Historic England

Our refs: P00493396/
P00495533

2nd September 2016

Thank you for your email of 19th July, and subsequent email correspondence, providing further information for our consideration regarding geological developments and implications at Pagham Harbour.

Block Plan Showing the Breach and Infill Area

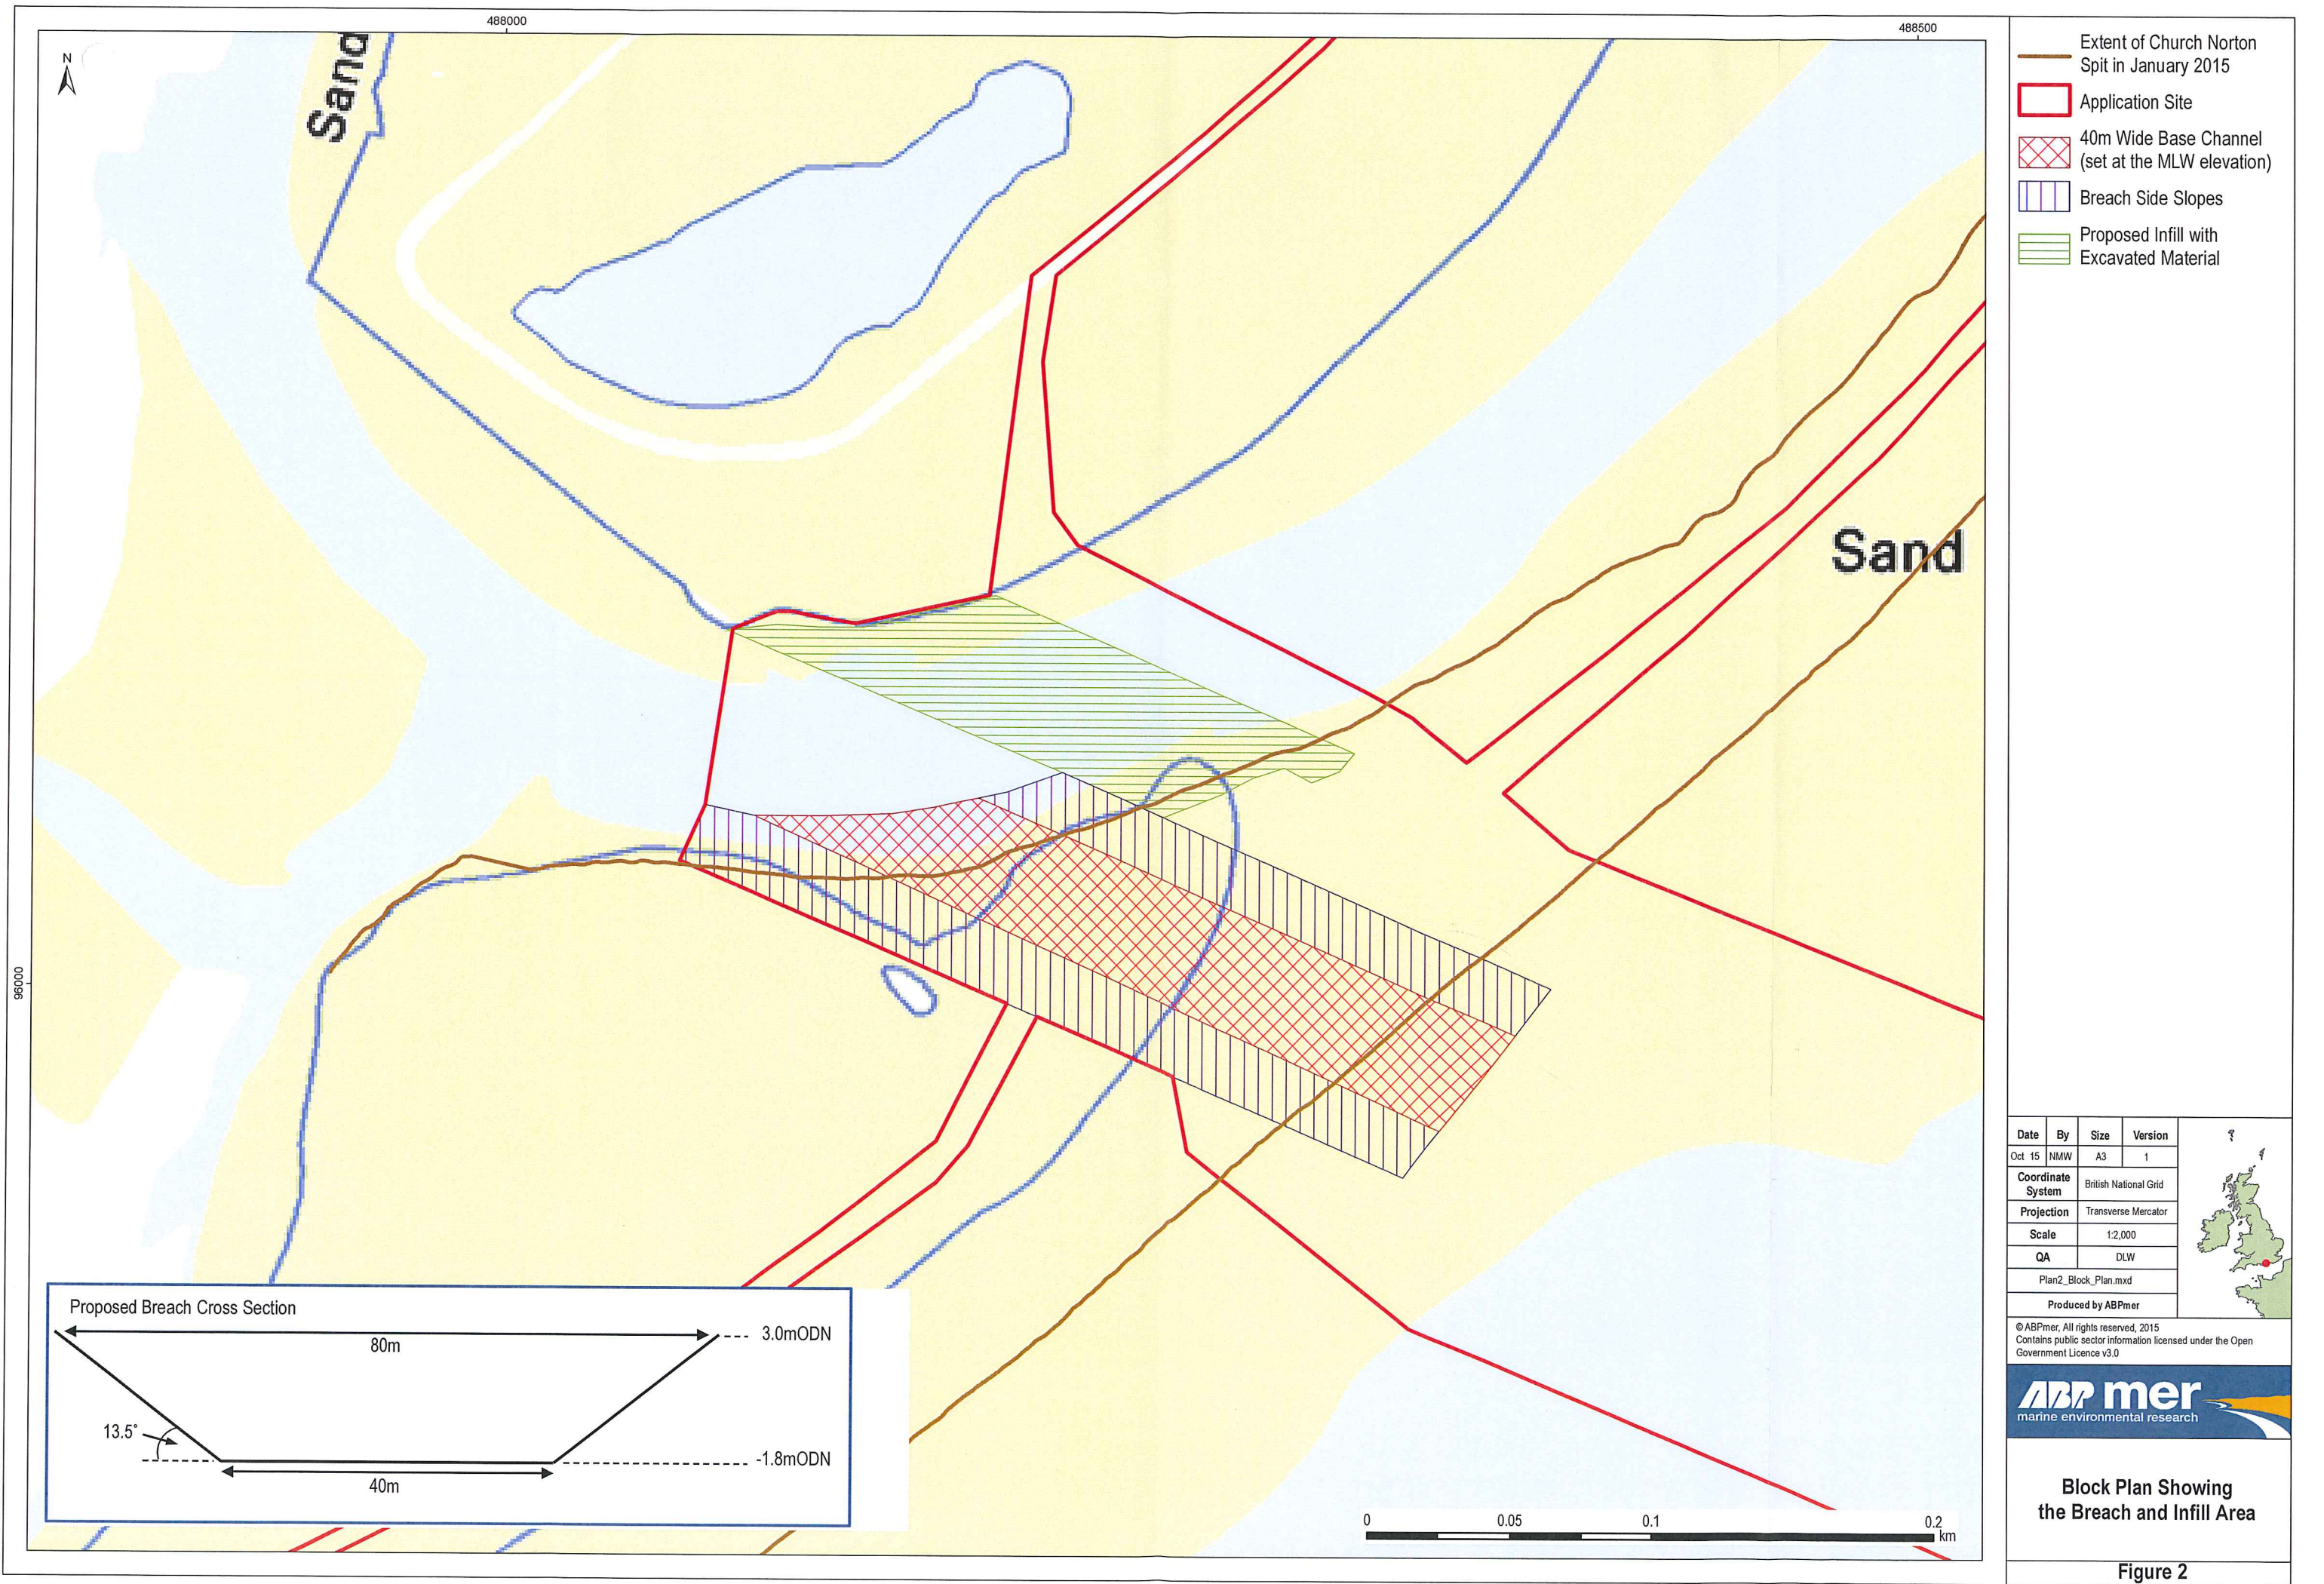
You have now informed us that since you submitted your planning application, there have been considerable changes to the coastal morphology of the outer seaward areas at Pagham. It is our understanding that the shingle bank has breached naturally and much of the area where the temporary causeway would be created has now become infilled with naturally deposited shingle.

We are therefore in agreement that provided there is no sheet piling in this area, it is unlikely that marine heritage assets would be impacted by any additional shingle deposition that may be required to complete the temporary causeway.

We understand that the spit has now breached naturally and artificial manipulation may not therefore be necessary, but should further works be required to enhance or widen the breach, then implementation of a reporting protocol would be appropriate.
